**Consultation Response from: KC Environmental Health (Pollution & Noise Control)**
**2023/93644 3, Knowler Hill, Hightown, Liversedge, WF15 6PH**
**Discharge conditions 3 (materials), 5 (boundaries), 6 (e v charging), 8 (ecology report) on previous permission 2023/91541 for erection of detached dwelling, formation of vehicular access and parking areas, and demolition of existing detached garage**
**Date Responded:  
20<sup>th</sup> December 2023**
**Responding Officer:  
RM**
**Responding Ref:  
WK/202340276**

**Condition 6 - Electric Vehicle Charging (EVC)**

Drawing Title
 DETACHED HOUSE

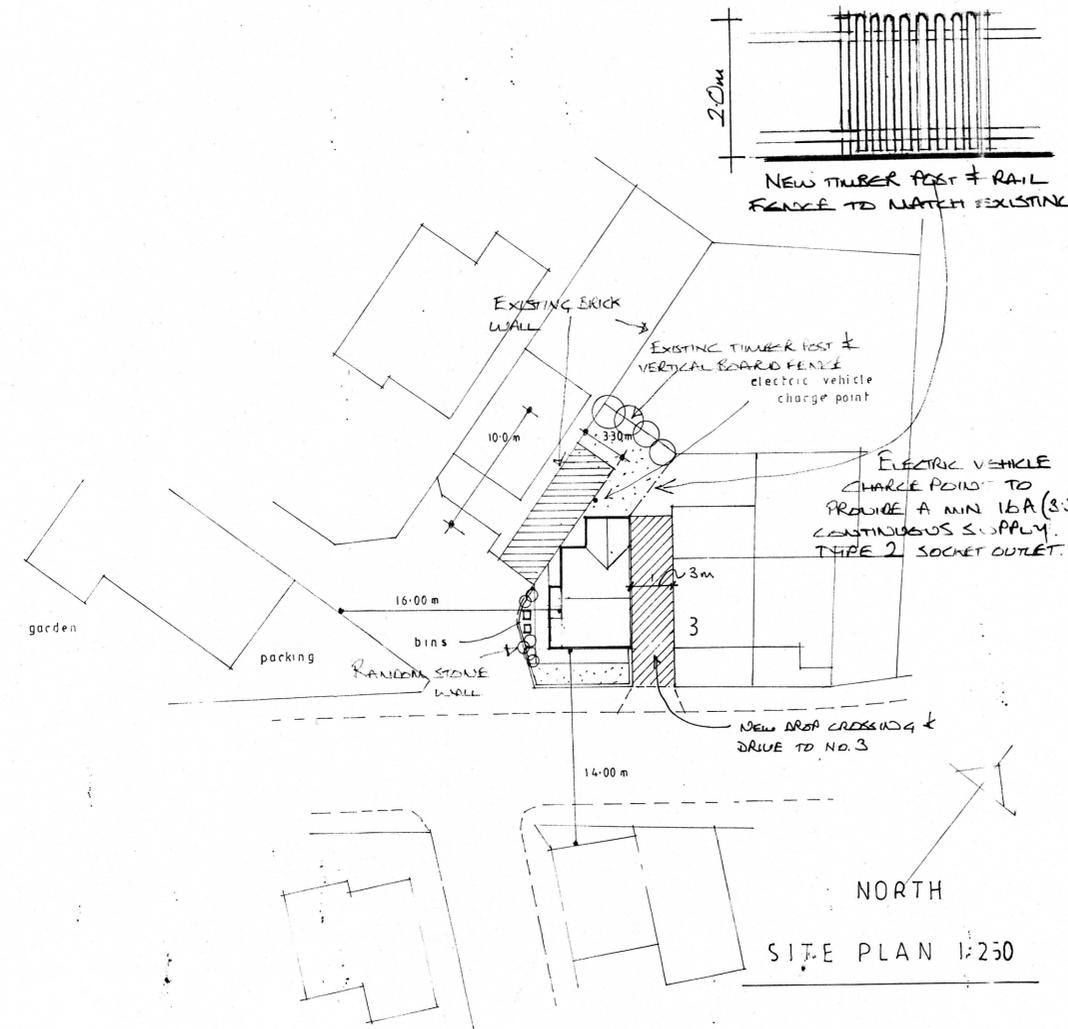
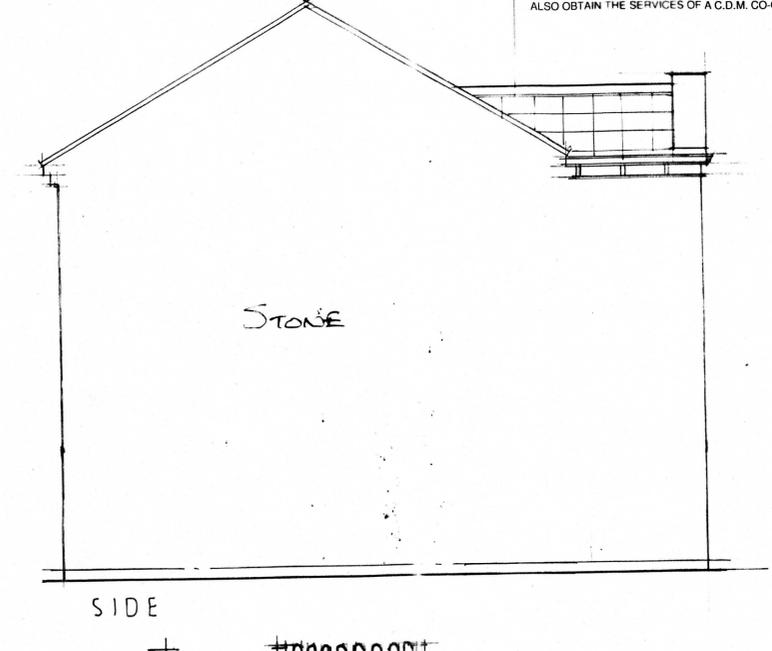
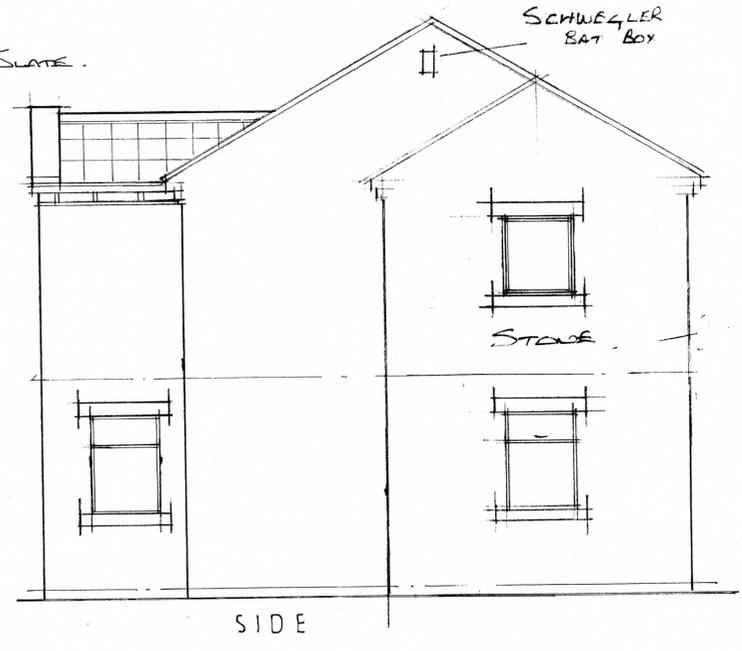
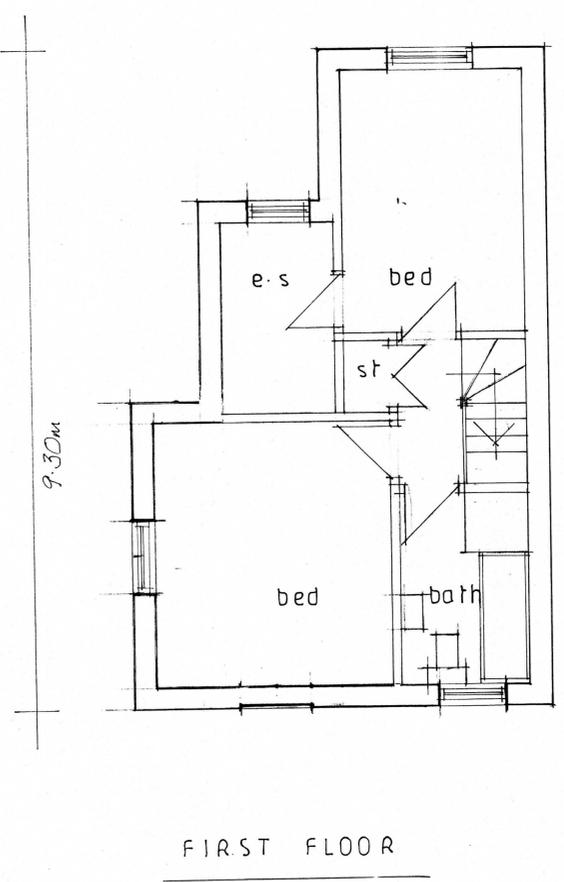
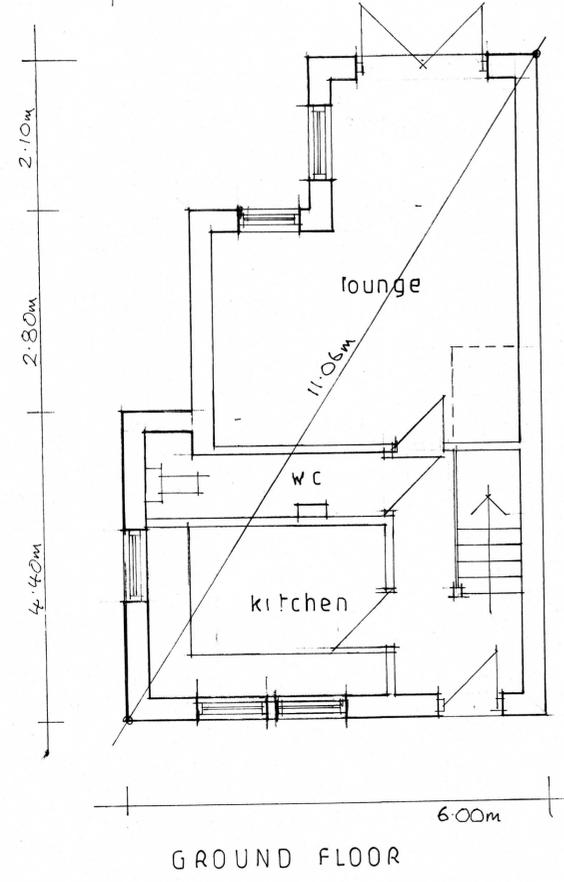
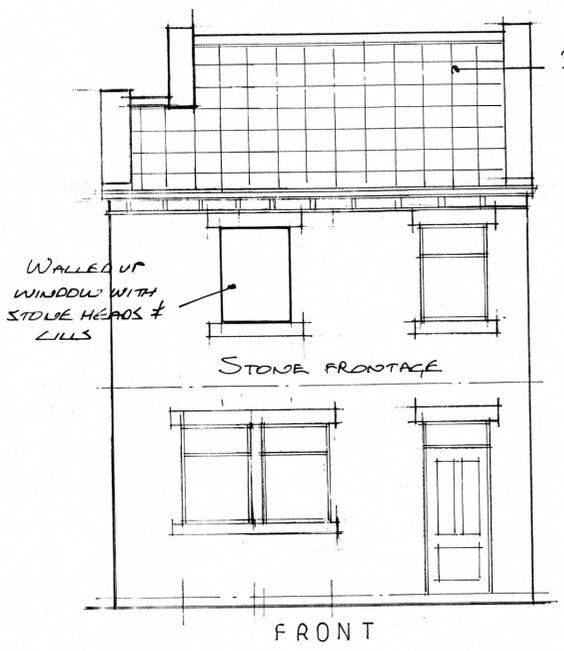
To discharge condition 6 a plan titled Detached House by J.A. Oldroyd & Sons Ltd (Drawing No. 22146A) (dated May23), has been submitted. The drawing shows the proposed location of the EVC point in relation to the dwelling and the annotation illustrates that the EV Charger will be a 16A (3.5kW) continuous supply, type 2 socket.

We are satisfied that the information provided meets the requirements of condition 6, however we cannot recommend that the condition is fully discharged until the EV Charger has been installed as per the said Drawing and is fully operational.
